Application No: M/98/25/HH
Site Address: 1 Elmer Court Elmer Middleton-on-sea PO22 6JT
Description of works: Extension and alterations to form a rear facing balcony and sliding doors (part retrospective).

Thank you for your internet representation made on 16th January 2026 which has been recorded as an objection with the comments as follows:

05 SIDE (WEST) ELEVATION:

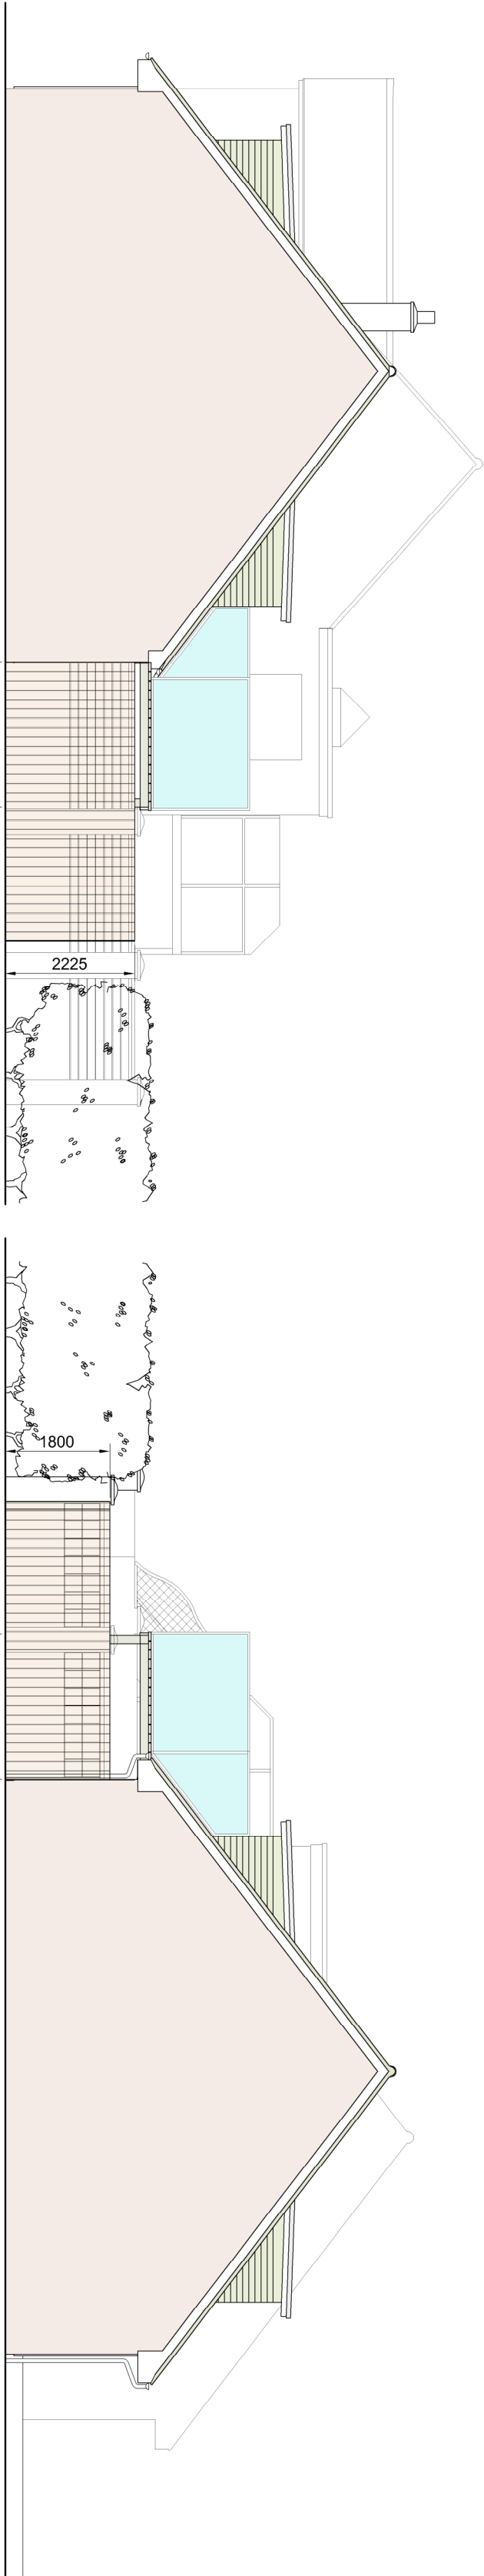
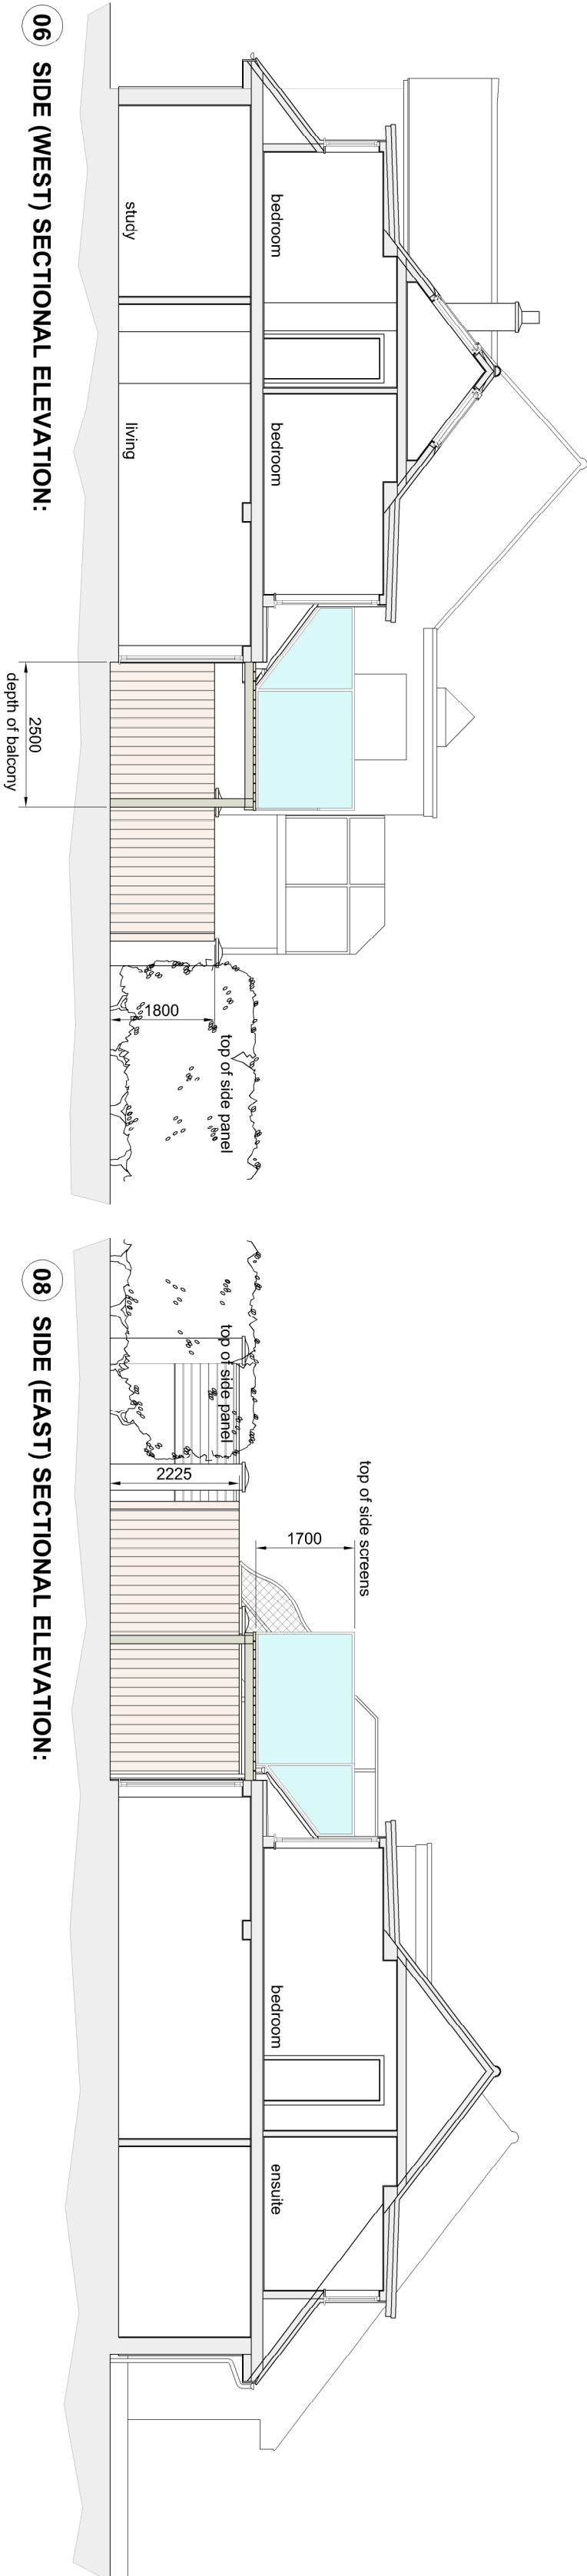
It will still be an overbearing structure as it has been built up to each of the neighbours boundaries meaning both properties will suffer from lack of privacy, overlooking and noise disturbance from any occupants on the balcony.
